WISWELL PARISH COUNCIL

Planning Application No: 3/2012/0010 (Amendments)
Demolition of all buildings on site (existing house, kennels and various outbuildings)
and erection of a new dwelling
The Eaves, Pendleton Road, Wiswell, Clitheroe, Lancashire, BB7 9BZ

SECOND FLOOR PLAN
4 No Bedrooms

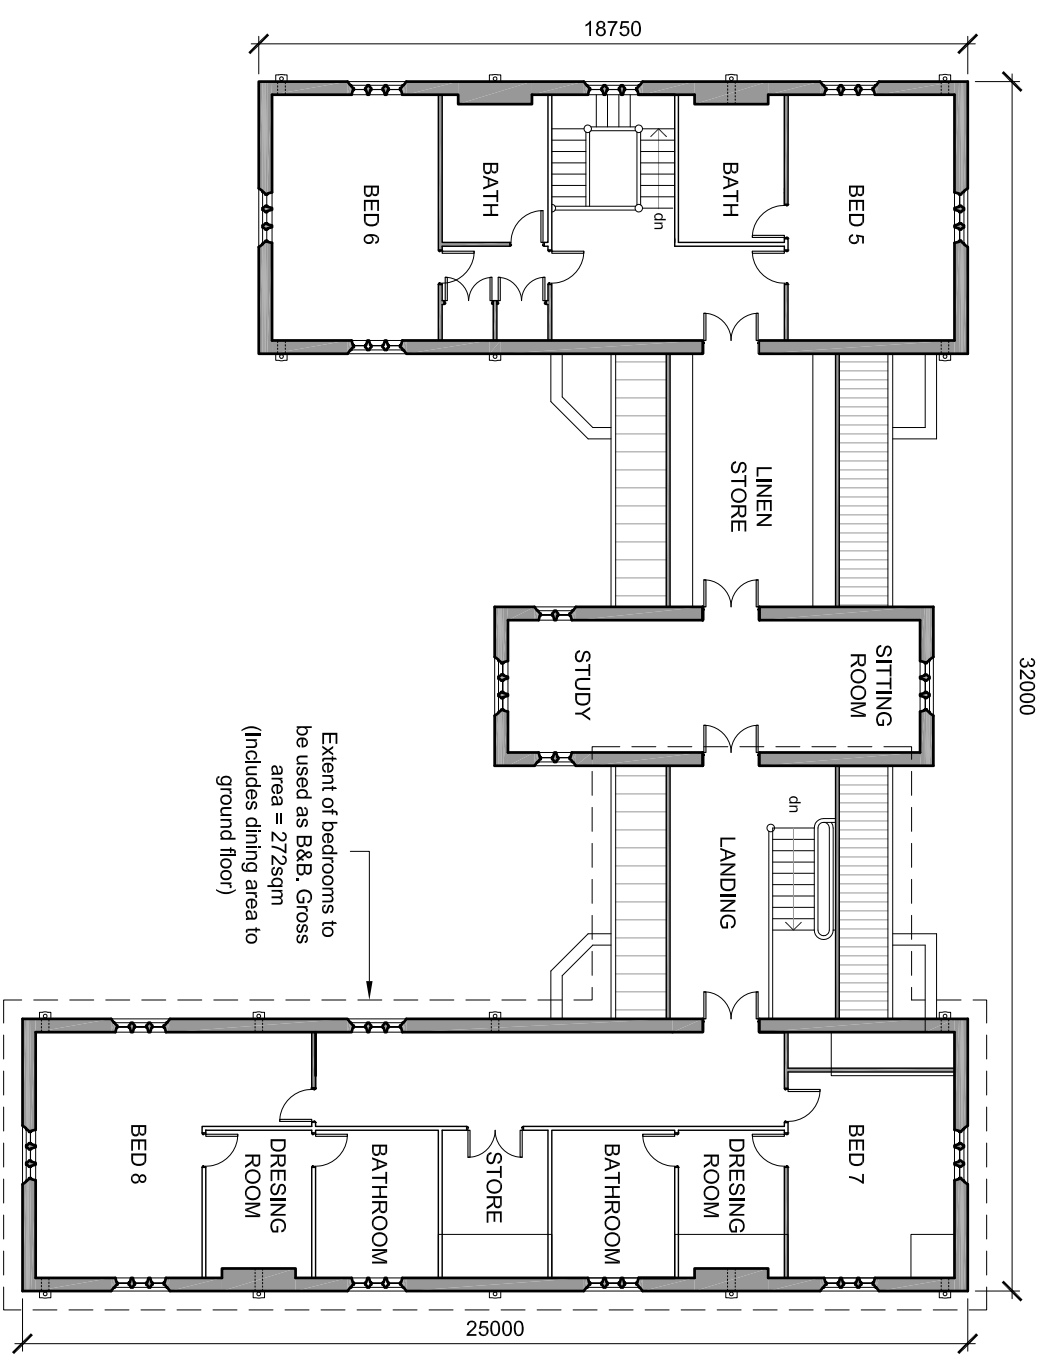
The Councillors have noted that the amended plans show that a gross area of 272 sqm of the dwelling will be used for the bed and breakfast business. However, as this figure includes a dining area on the ground floor that is a shared space used by the family and not solely as part of the business, the Councillors believe that this space should not be included in the calculations of business usage.
